June 16, 2021

RE: Winsome Filing No. 2 TIS Response to Comments

Kellar Engineering (KE) comment responses in **blue** font.

Figure 2: Site Plan (Filing No. 2 in Green)

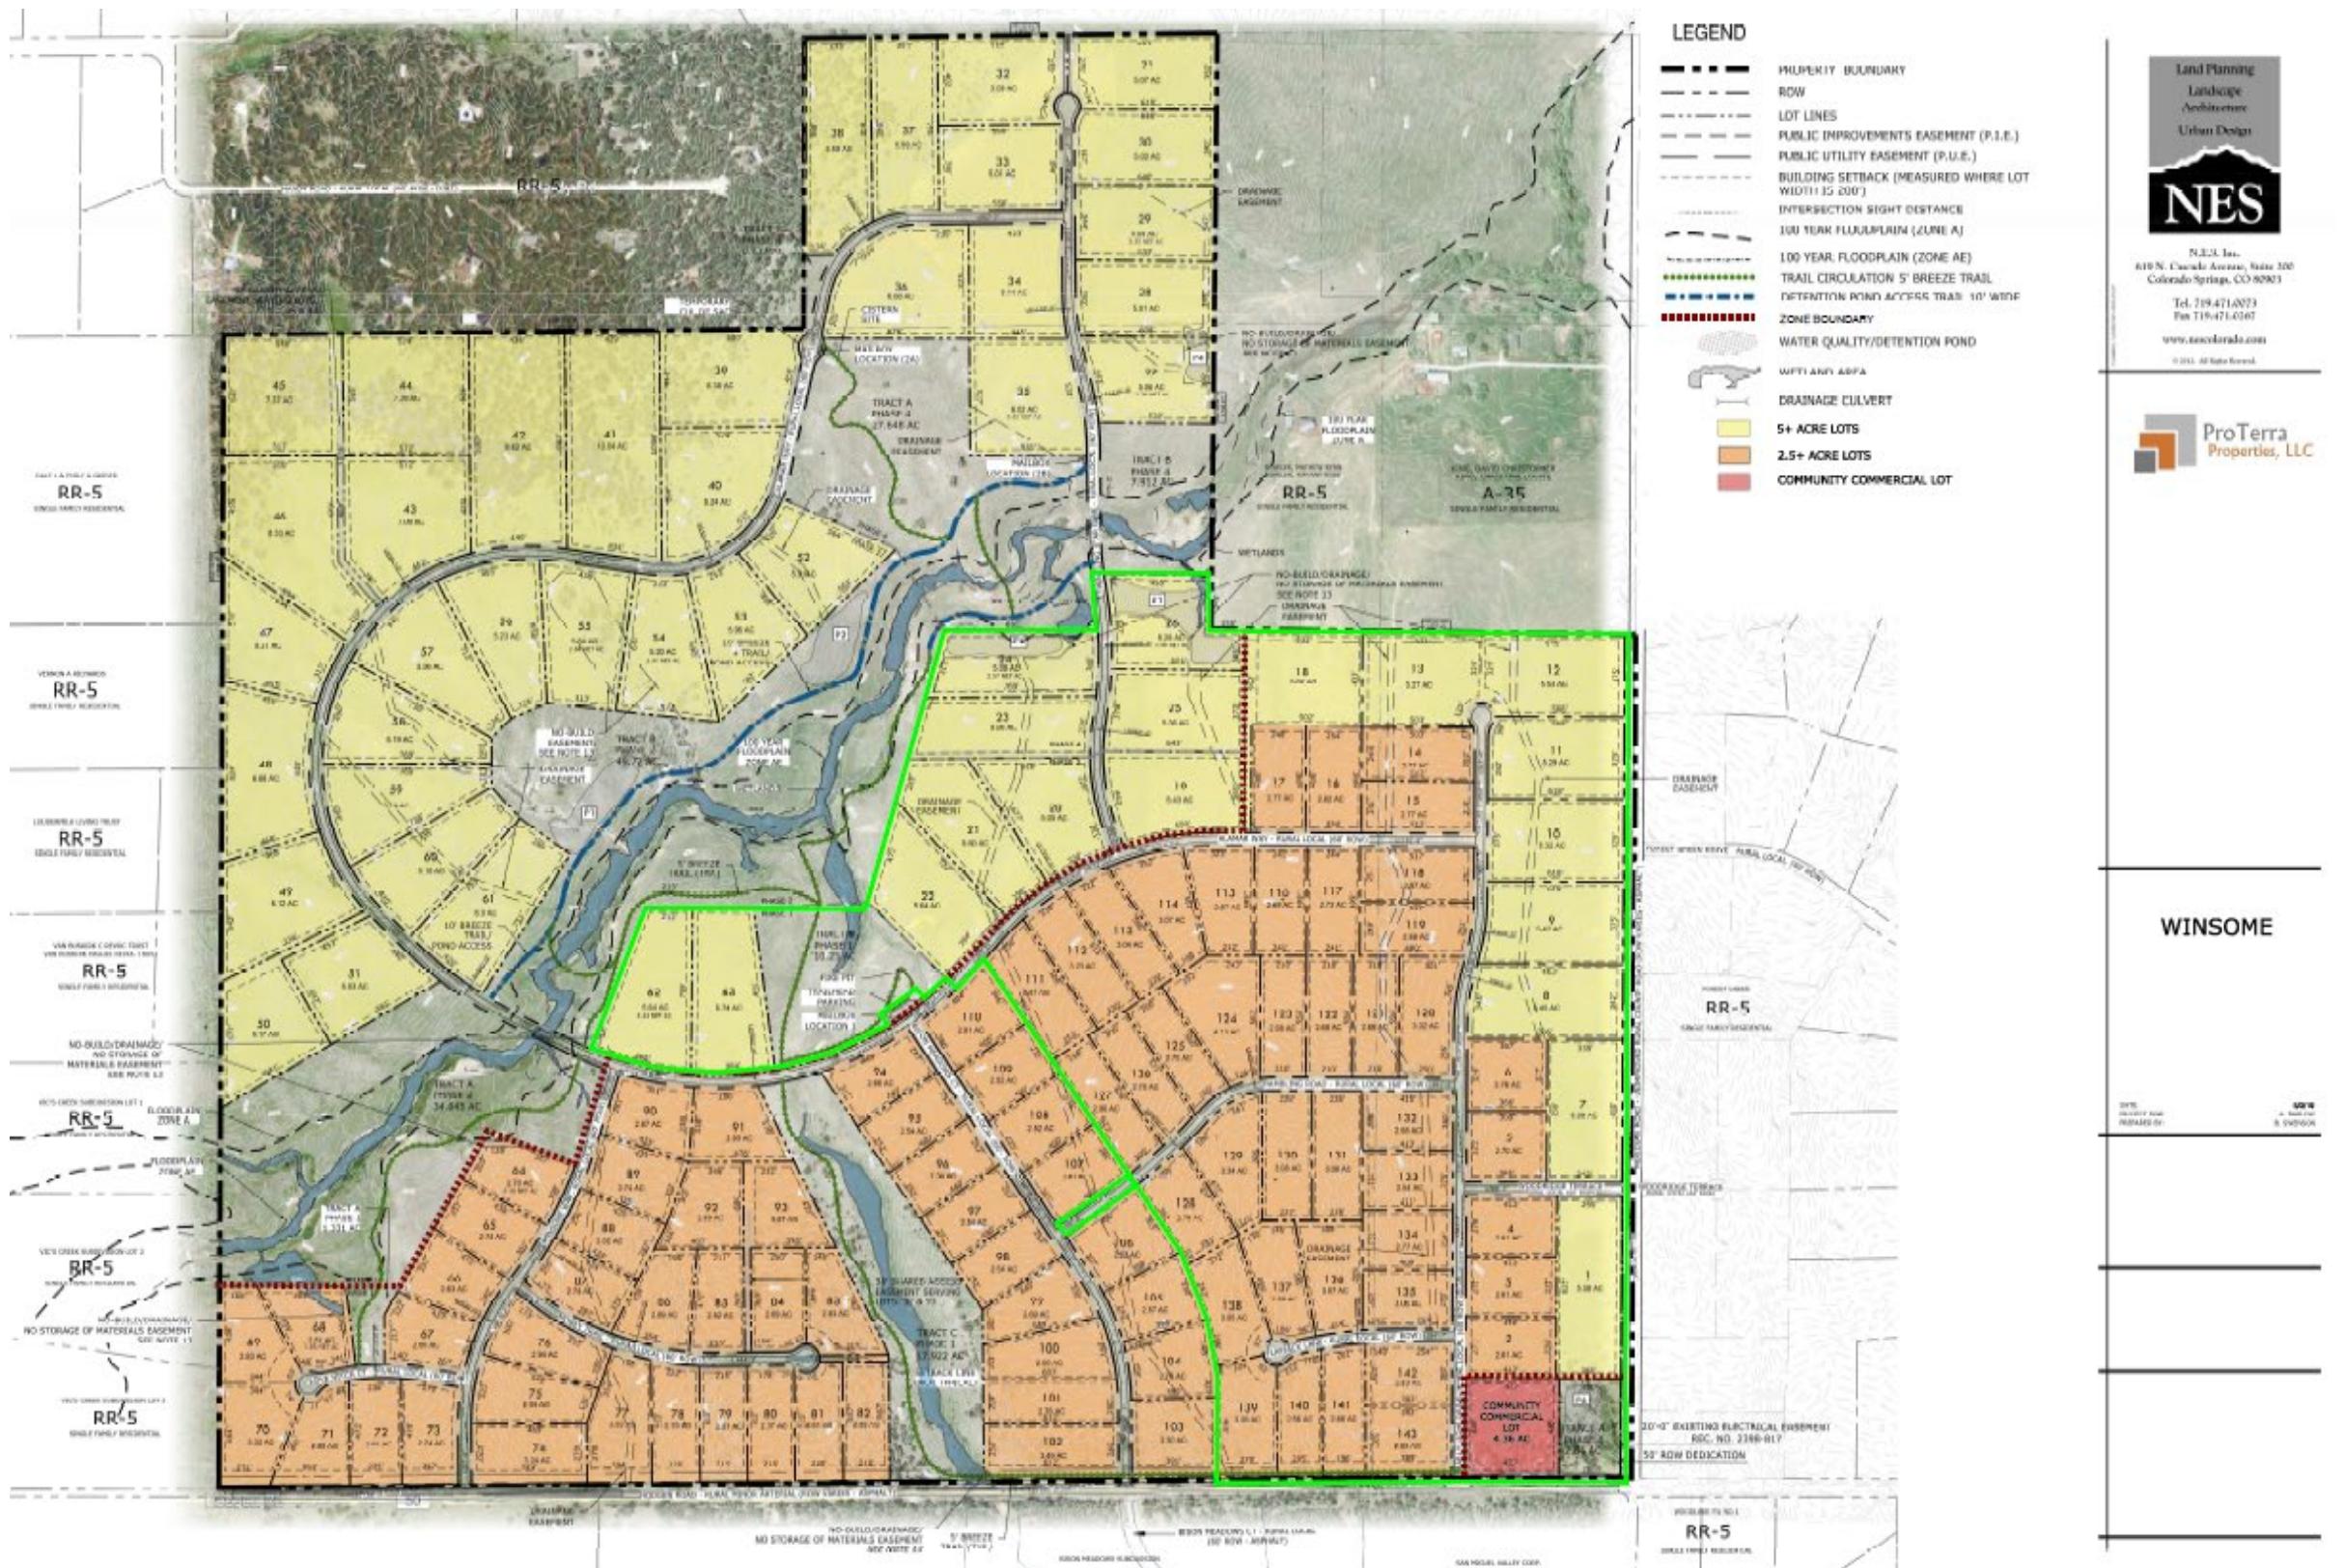
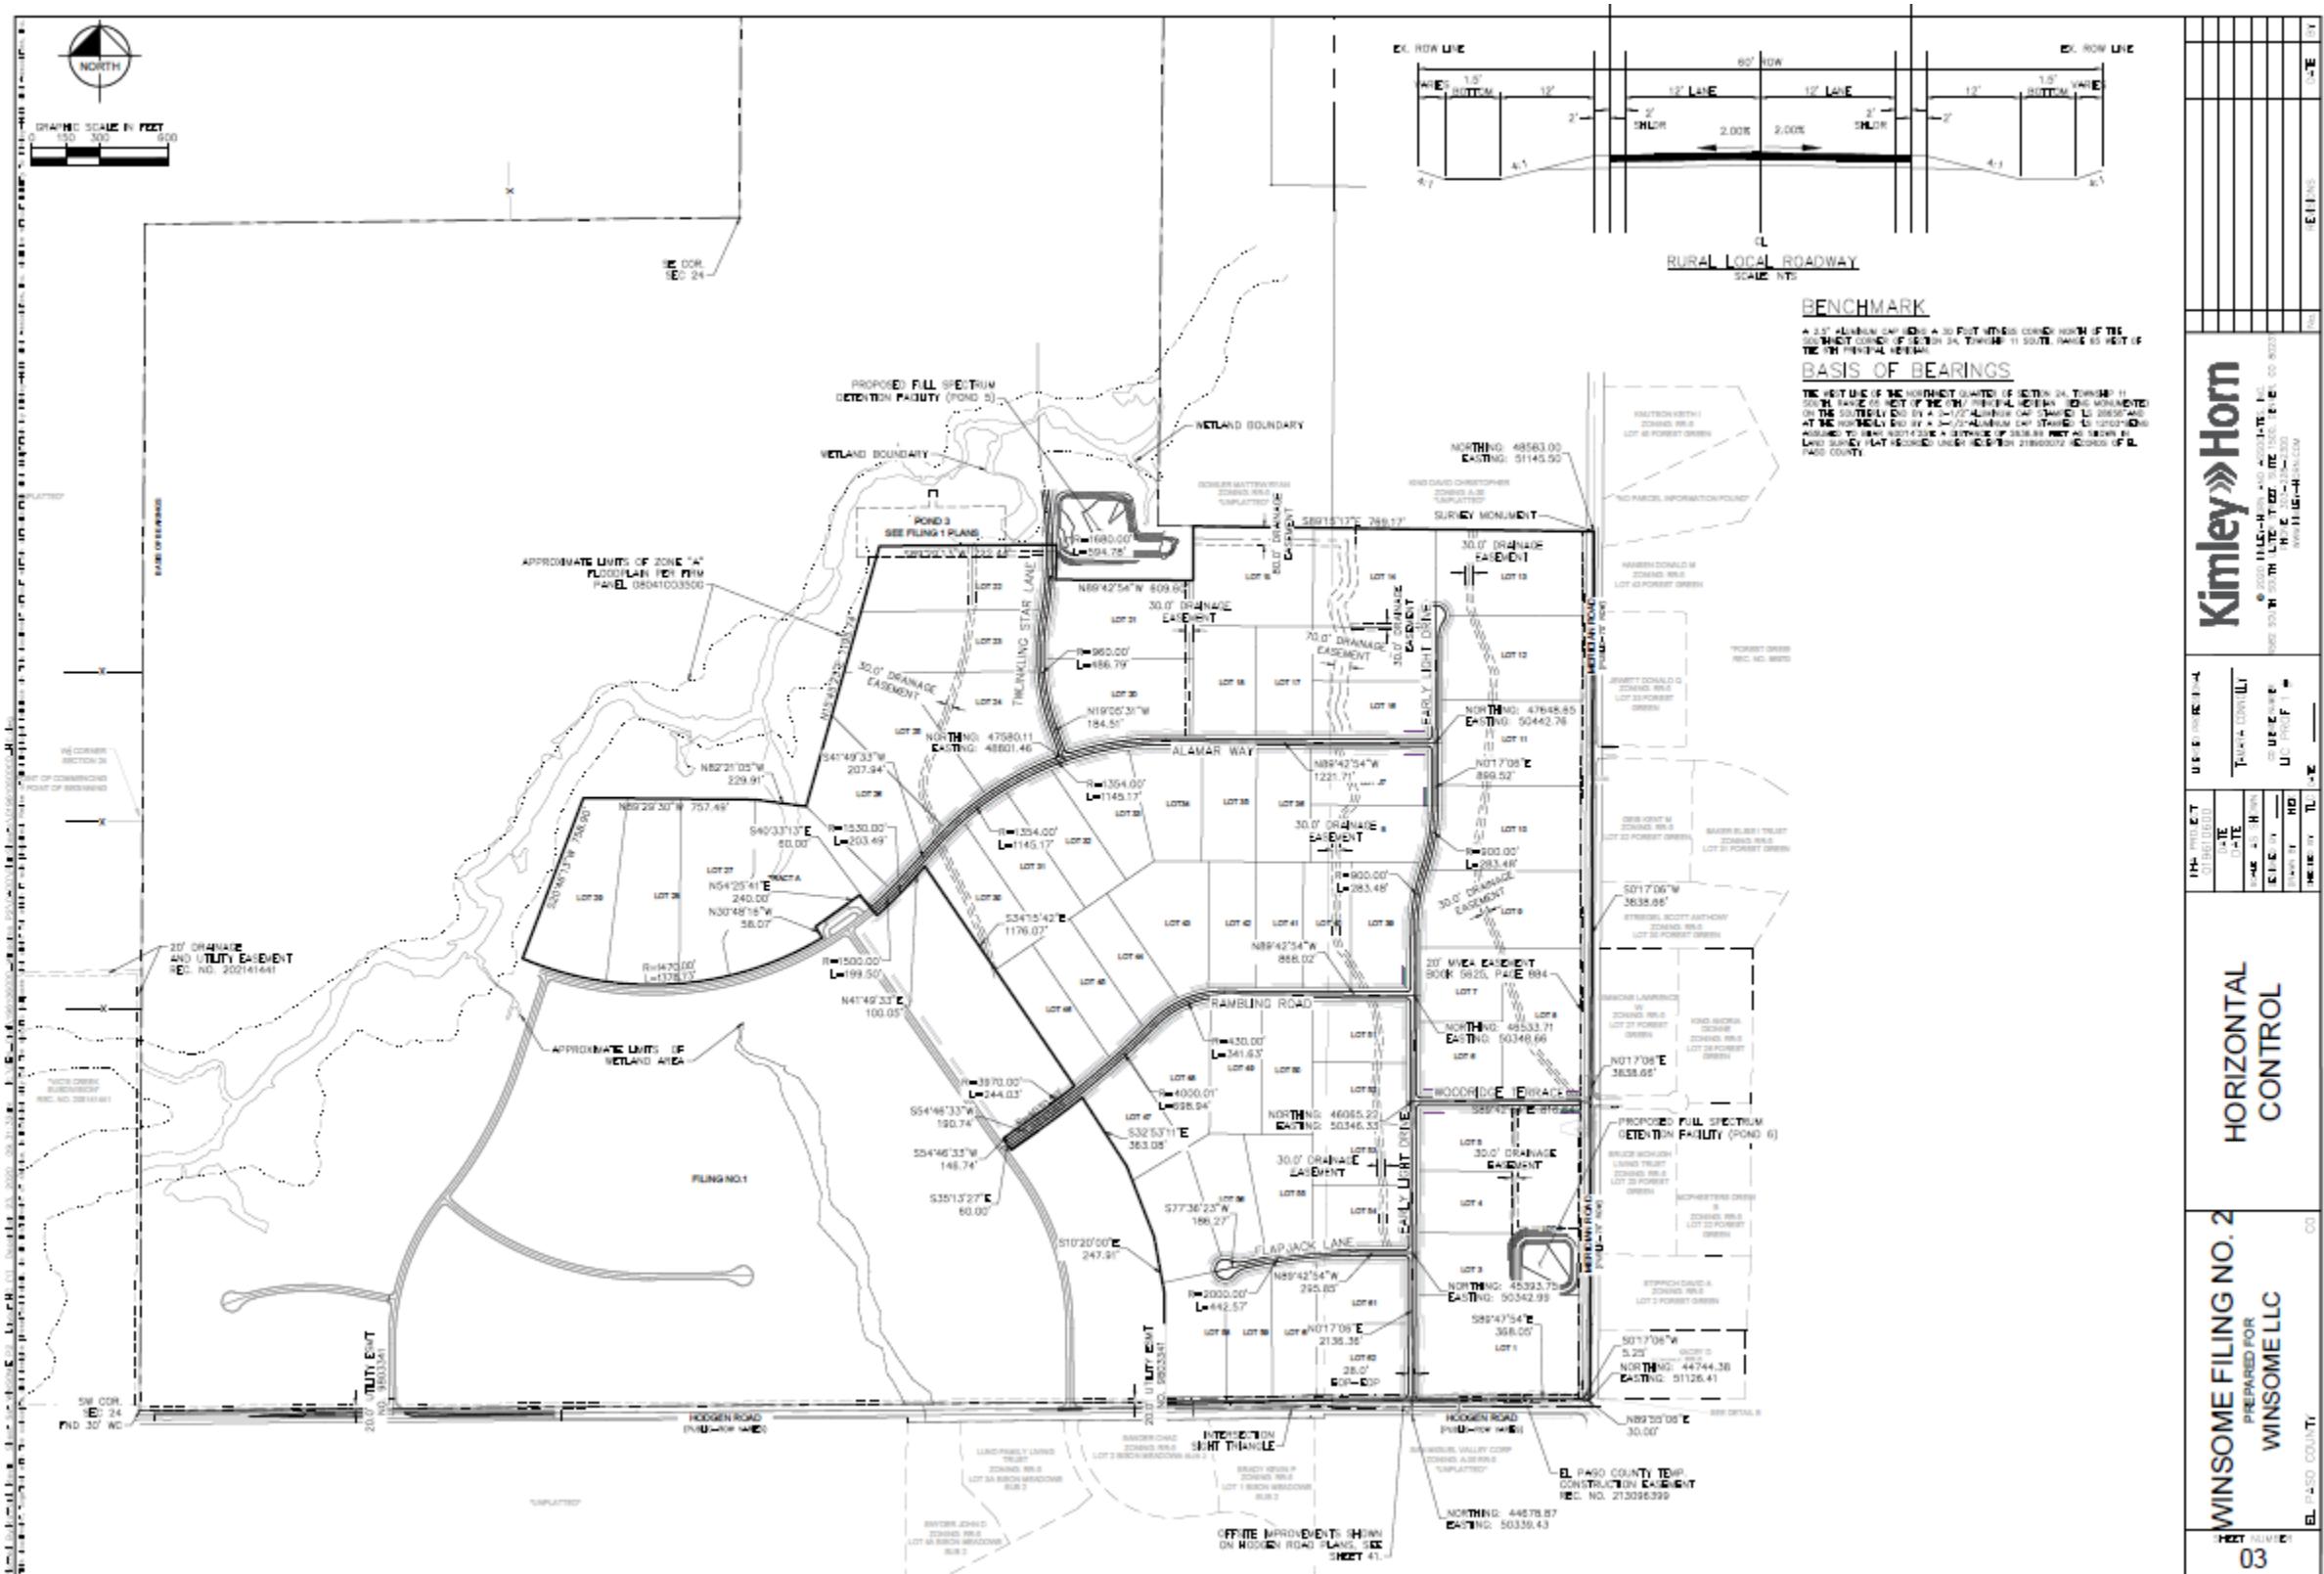
1. Comment. Update to SF-21-015
Response. Cover sheet of TIS updated accordingly.
2. Comment. Update access to include Woodridge Terrace/Meridian Road.
Response. TIS updated accordingly to include Woodridge Ter./Meridian Rd. in Section 3.0.
3. Comment. SBRT meets criteria for exclusive right turn at Early Light Drive/Hodgen Road. Deviation request from ECM Section 2.3.7.D.2 for the County Engineer's determination since the TIS recommendation is not to install an exclusive right turn lane.
Response. TIS updated in Section 5.0 to include a recommendation for the SBRT lane at Early Light Drive/Hodgen Road.
